Recommendation Report for Planning Permission for Works or Extension to a Dwelling

REF NO: EP/84/20/HH

LOCATION: 19 South View
East Preston
BN16 1PX

PROPOSAL: First Floor extension over existing single storey side extension. Demolition of existing conservatory and construction of new two storey rear extension.

Front Elevation (south)

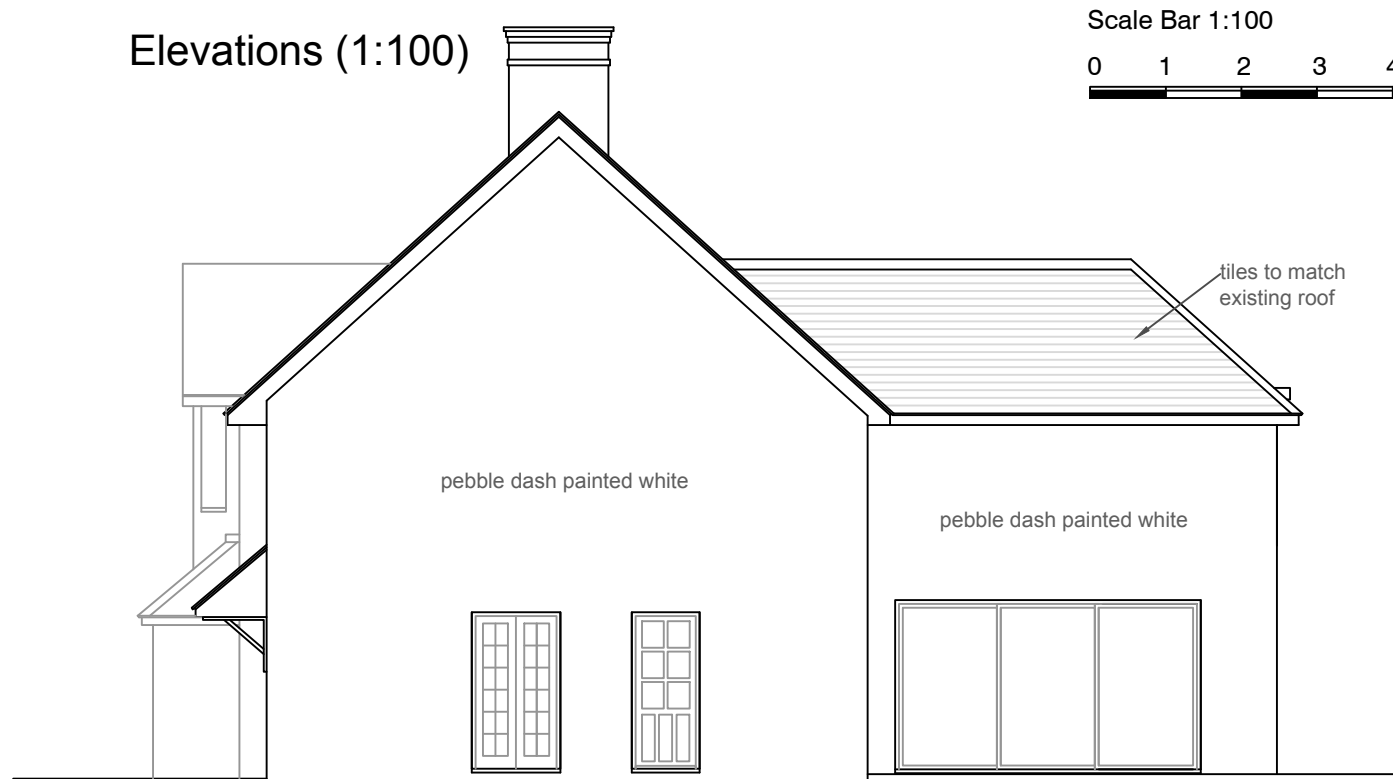
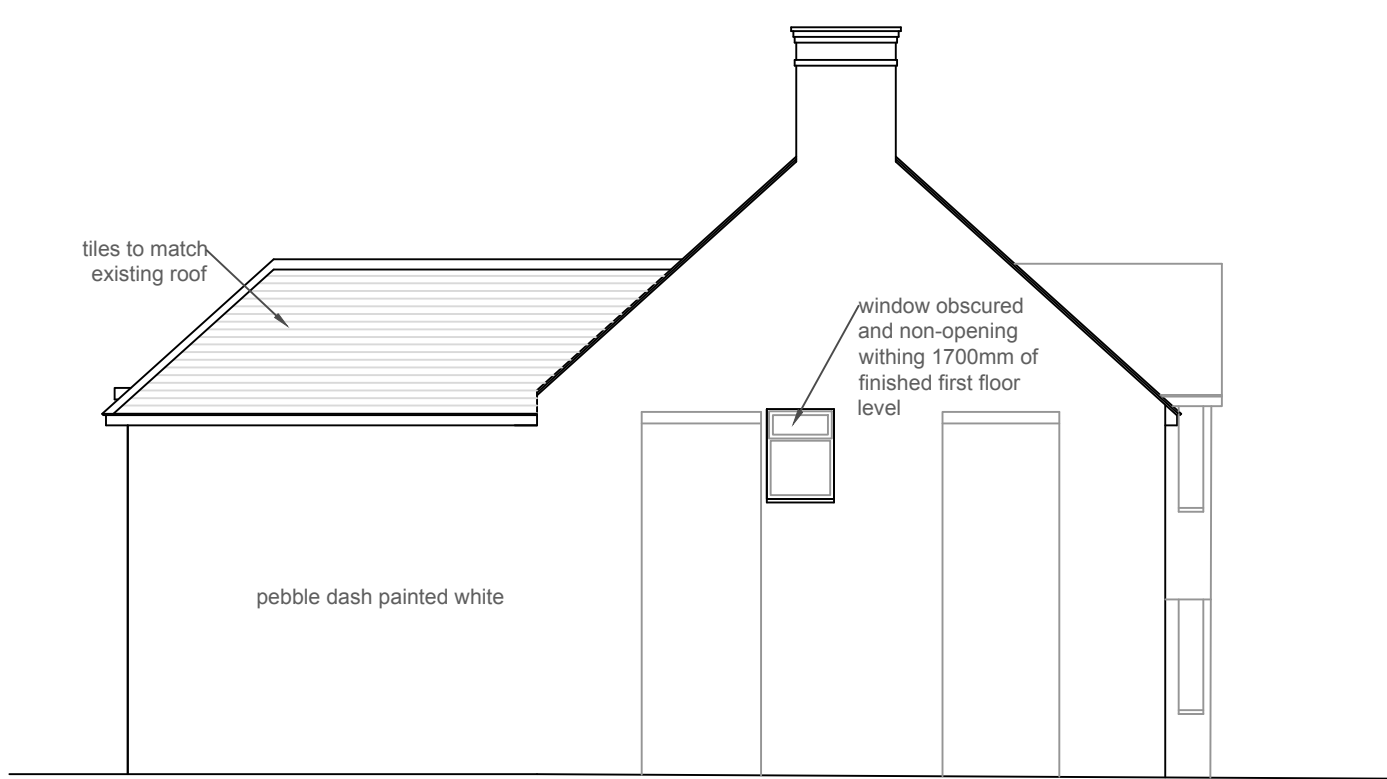
The only part of the extensions proposed which would affect the street scene are 1.4 metres widening of the house at the front elevation on the east side. This is not considered to have a significant impact and would not affect the character of the building as it is only a small addition. The extension above the ground floor at the side would have an acceptable impact on the dwelling as a whole because the limited scope of the addition would complement rather than dominate the existing building .

The rear extension would be substantial but would still be subservient to the dwellinghouse as a whole and would therefore be considered to have an acceptable effect on the character of the building.

The rear extension would not intersect a 45 degree line drawn from the centre of the closest habitable room window at 17 South View and therefore is considered to comply with the 45 degree rule which the Council uses to assess impact on neighbouring dwellings in terms of loss of light and overbearing impact. There are no windows in the side facing wall and therefore no impact on the privacy of the neighbouring dwelling at 17 South View.

Ground Floor Plan

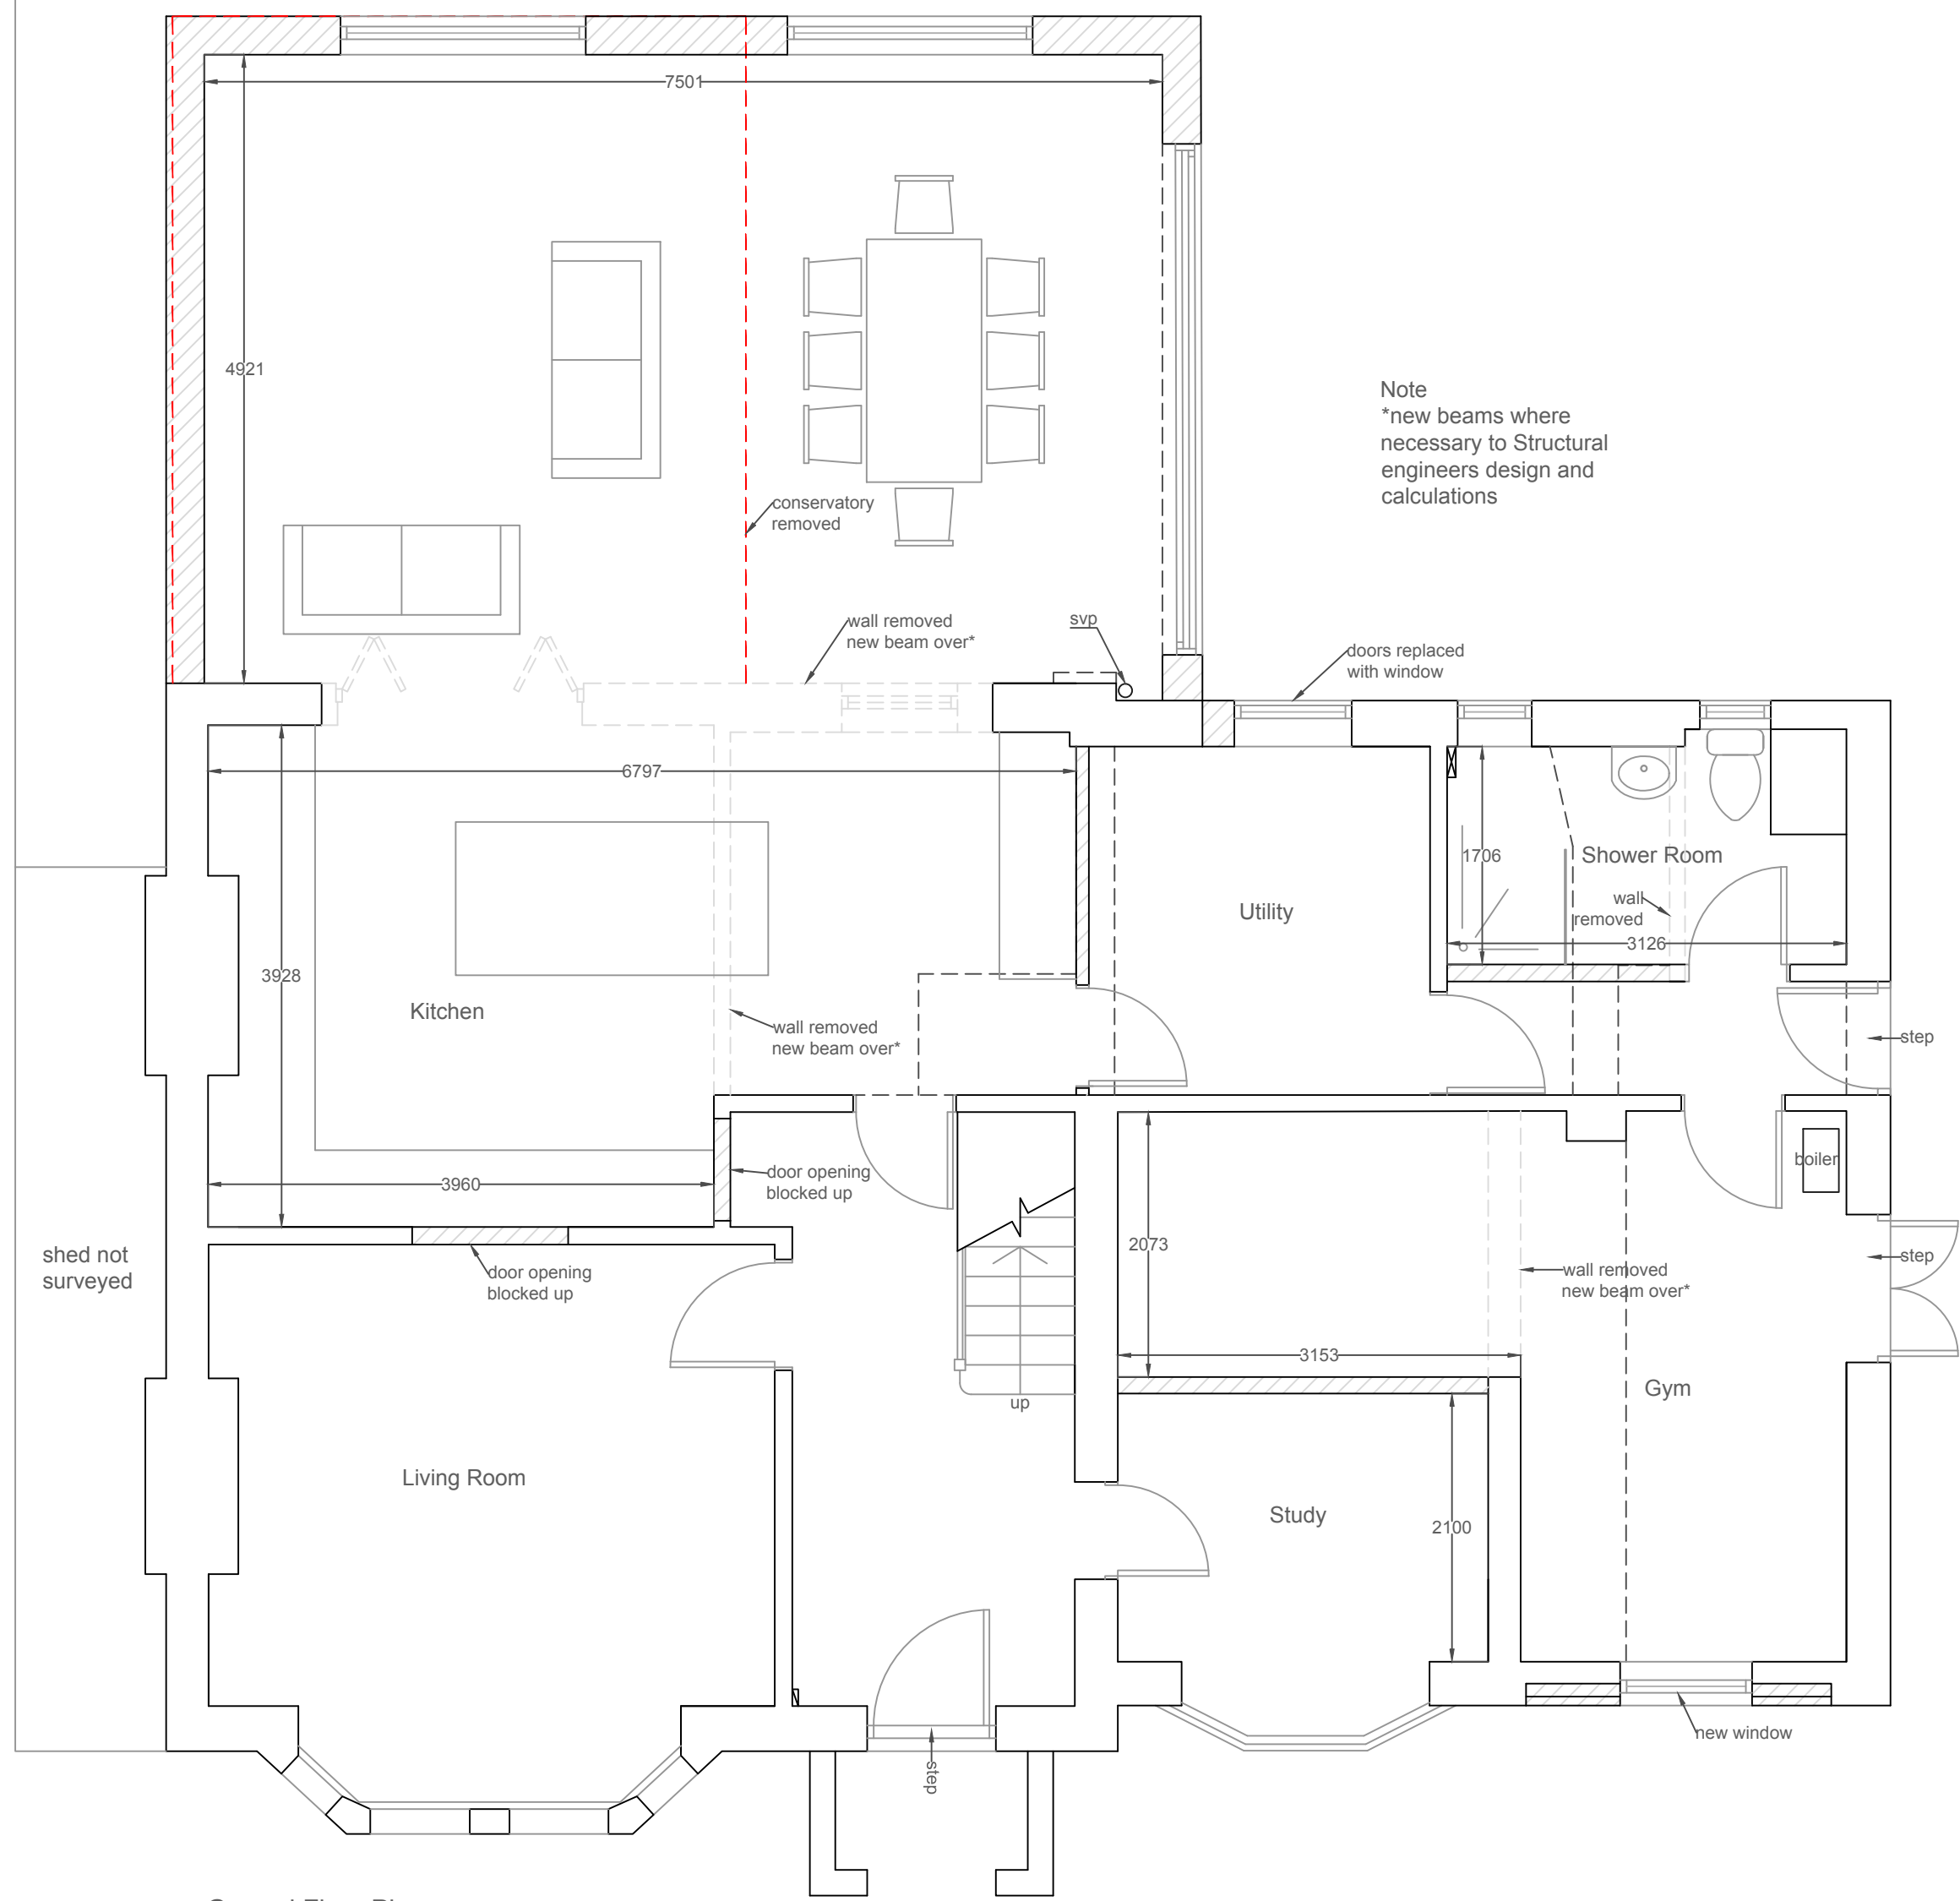
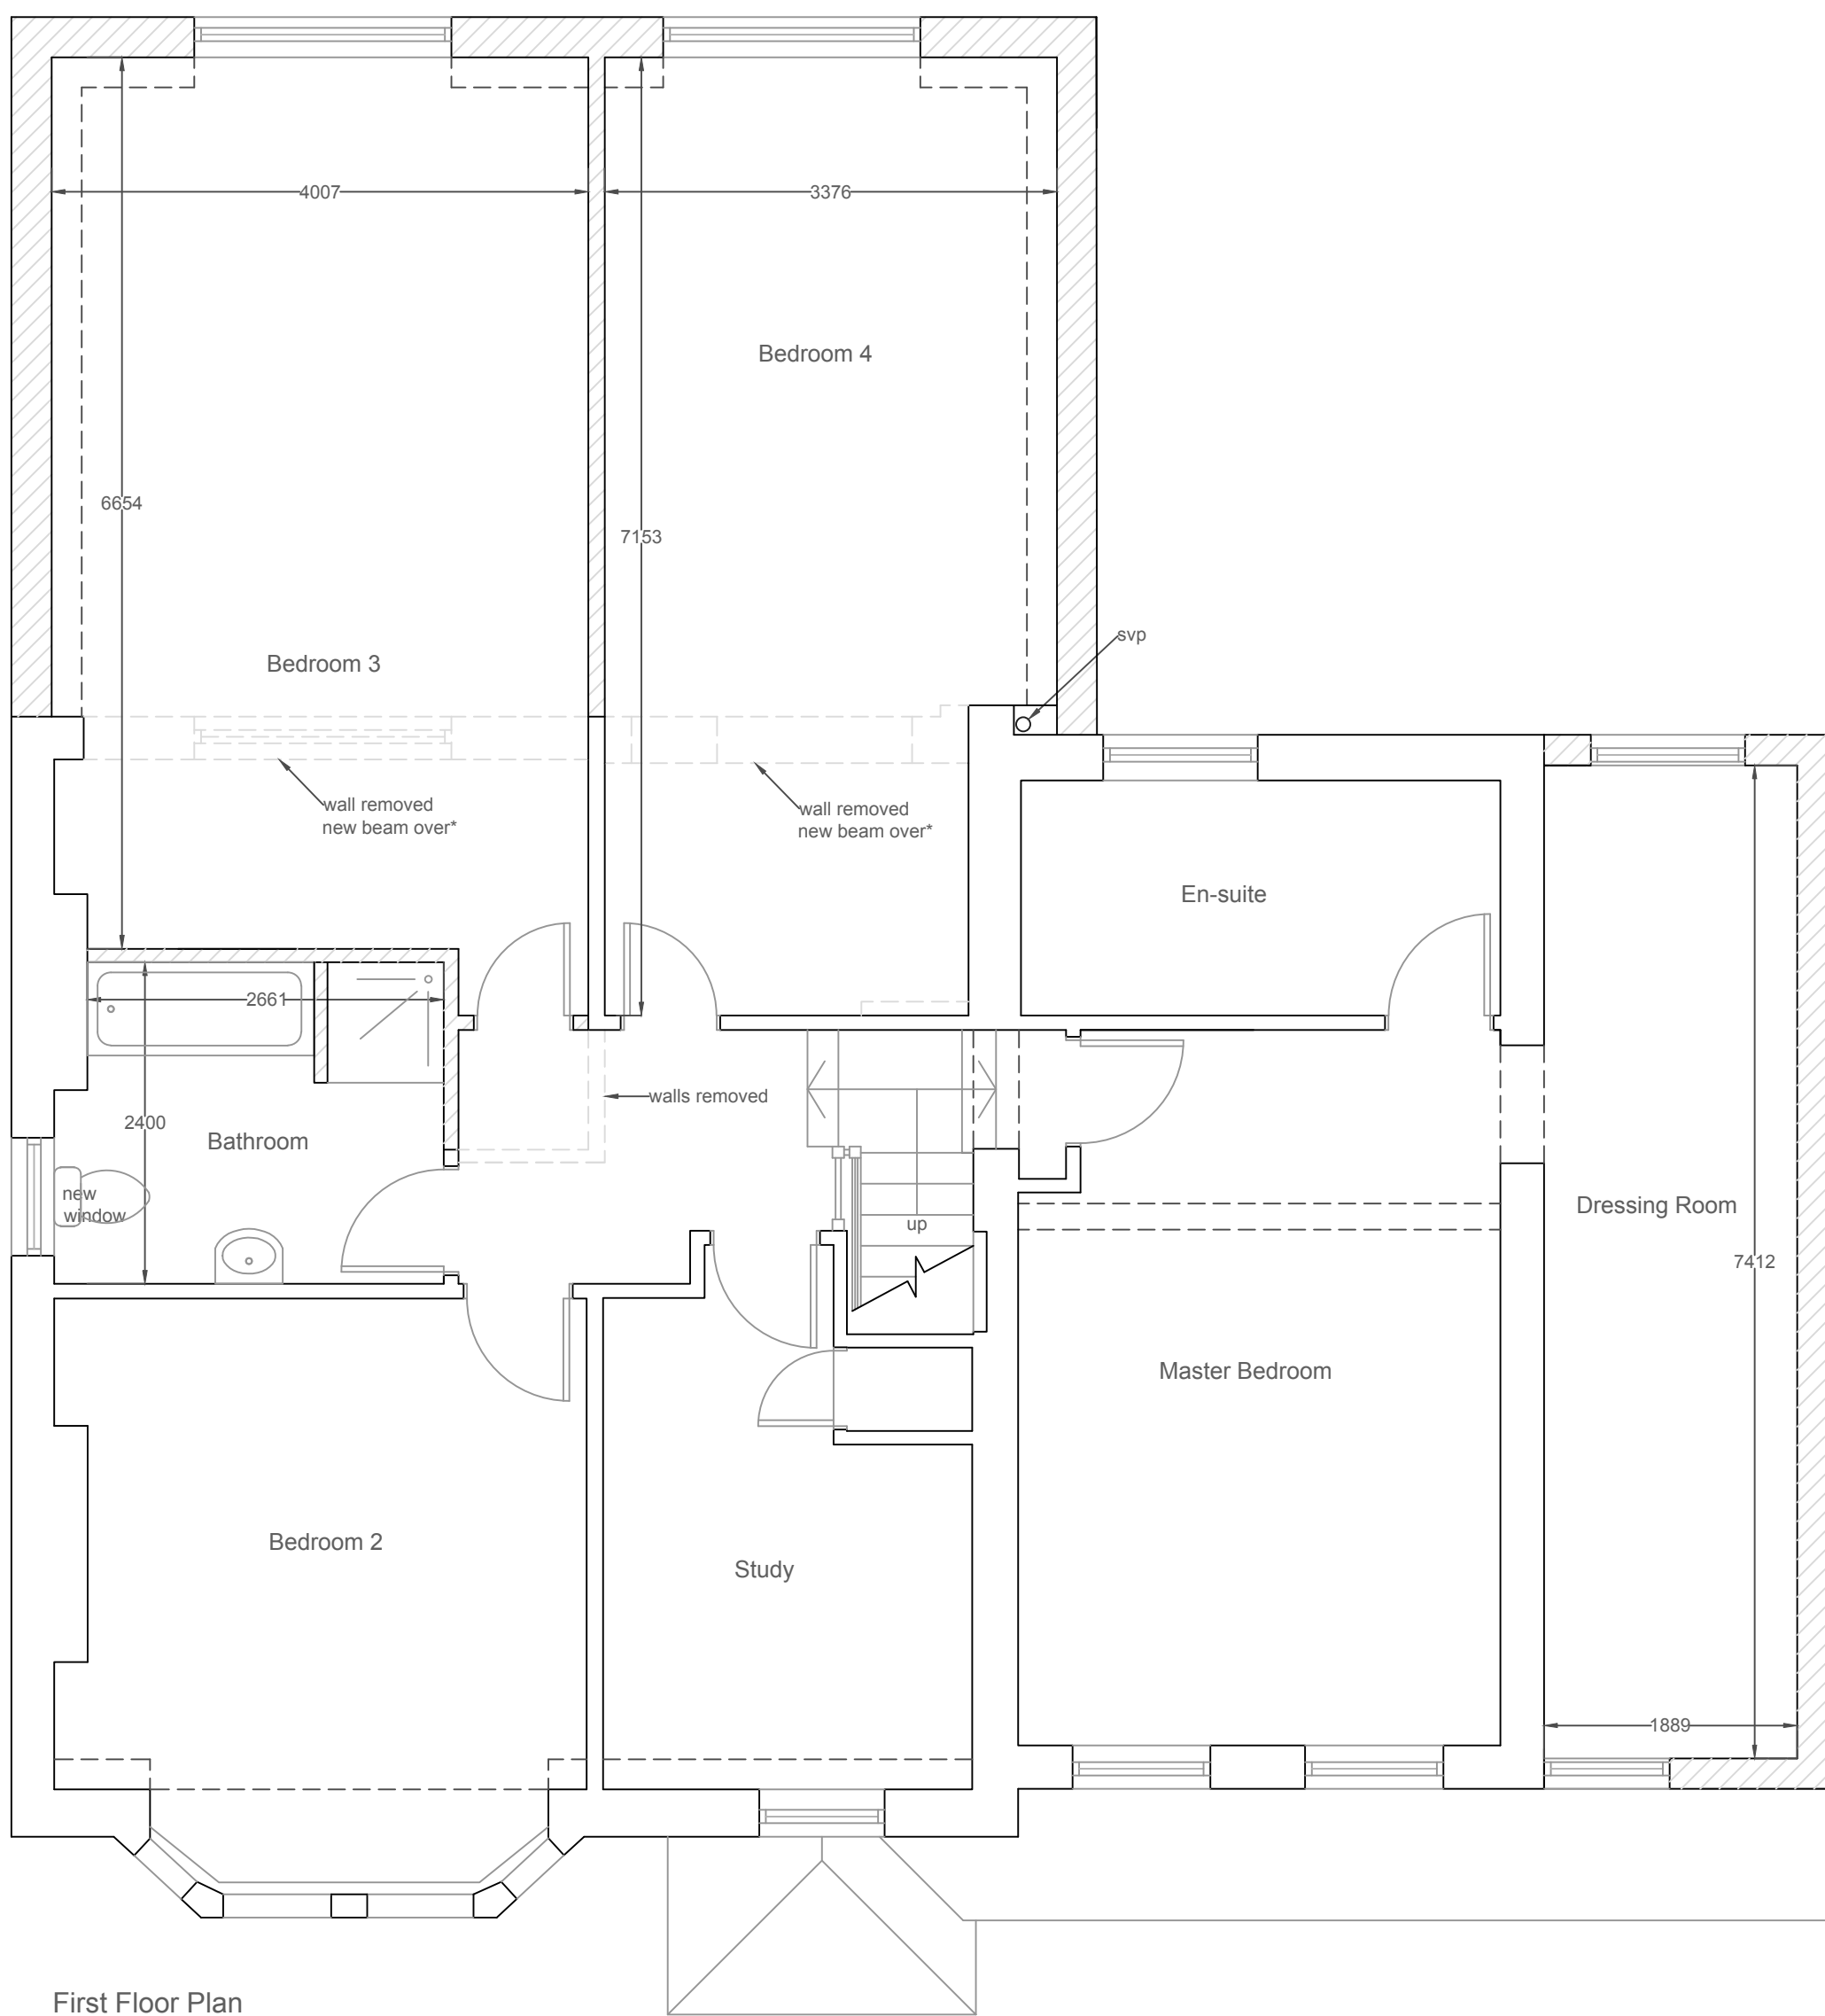
The side extension is limited at 1.4 metres in width and would not be considered to have any significant impact on neighbouring dwellings in terms of loss of light, overbearing impact or loss of privacy. The side facing window is to be obscure glazed and fixed shut below 1.8 metres in height which is considered acceptable to protect the privacy of the neighbouring dwelling.
